From: Simon Davis
Sent: 28 May 2019 13:31
To: Planning.Responses
Subject: FW: Planning Consultation on BE/60/19/DOC 182 Chichester Road
Attachments: 2024-SK3 surface water drainage.pdf; Calcs - Permeable Driveway-2.pdf; Calcs - Concrete Ring Soakaway-2.pdf

Engineers Comments Regarding Condition 4- surface water drainage

BE/60/19/DOC

182 Chichester Road Bersted PO21 5BJ

Client
Simon Abbot
Drawing Title
Surface Water Drainage

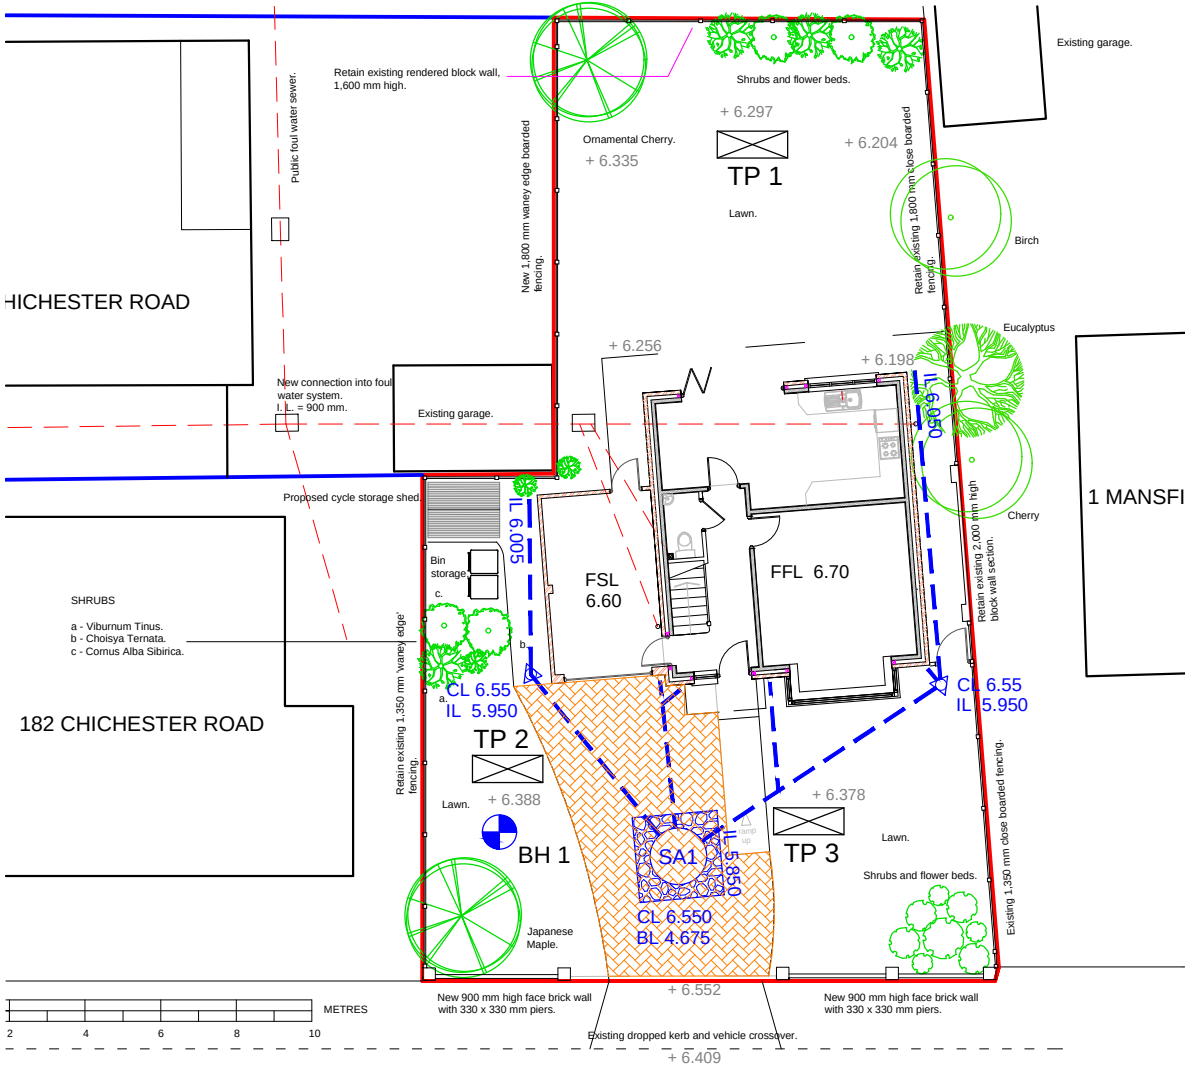
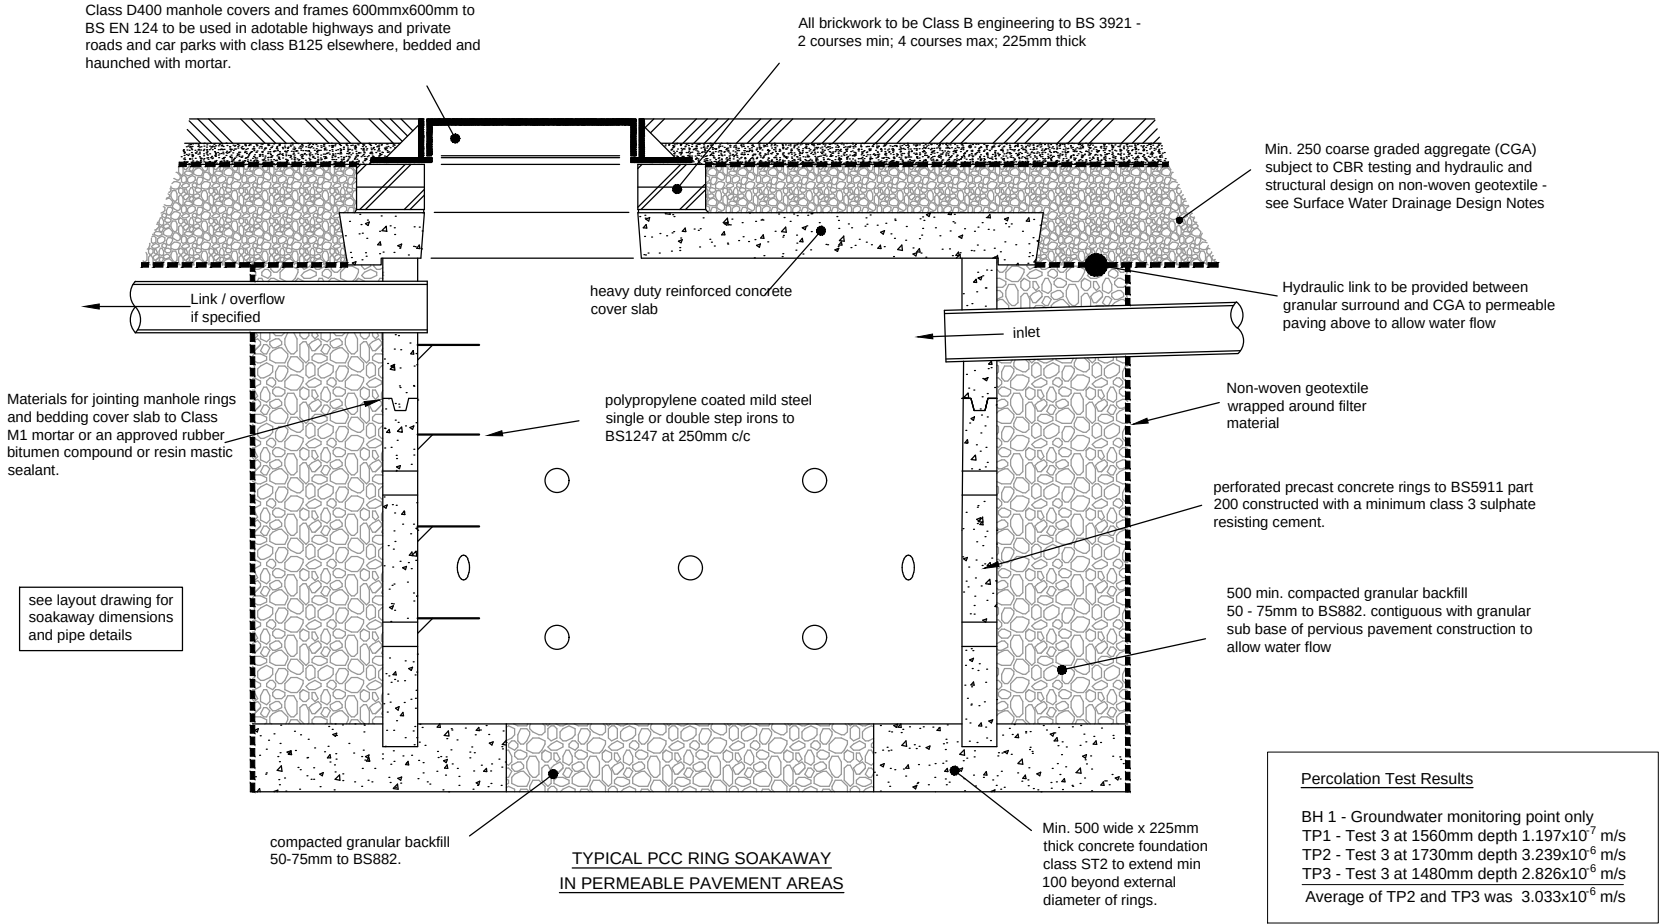
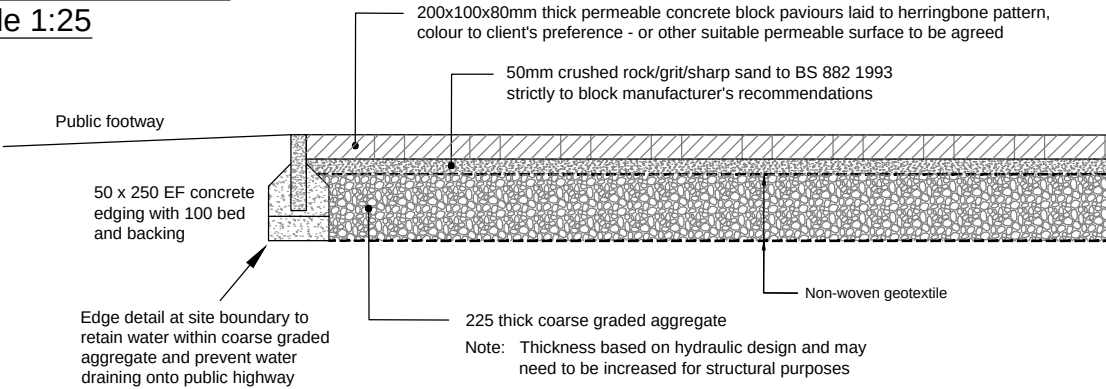
- No calculations have been submitted with the application. Please can these be provided.
- Average infiltration rates have been used in design. We require worst case results to be used. Please can further detail on the infiltration testing results be submitted, i.e. depths and locations of testing and results.
- It is unclear if winter groundwater monitoring has been completed. Please can the applicant confirm the duration of groundwater monitoring.

Client	Simon Abbot
Drawing Title	Surface Water Drainage

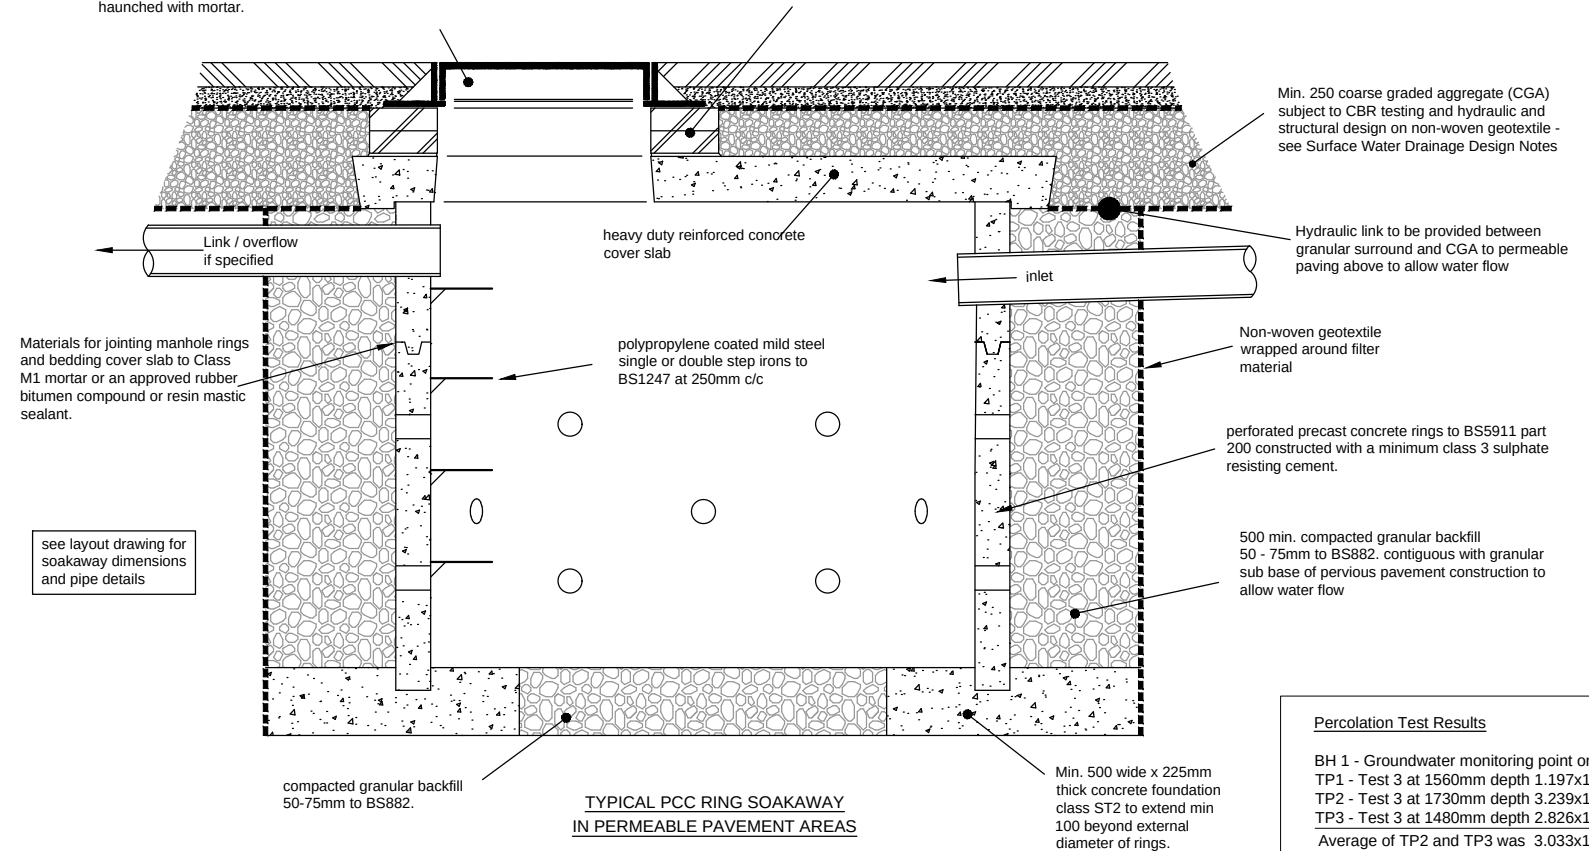
- Average infiltration rates have been used in design. We require worst case results to be used. Please can further detail on the infiltration testing results be submitted, i.e. depths and locations of testing and results.
- It is unclear if winter groundwater monitoring has been completed. Please can the applicant confirm the duration of groundwater monitoring.

I have revised the calcs as requested and it makes just 4mm difference in the subbase depth required from 214 to 218mm. I designed 225mm depth anyway, so there is no change to the design
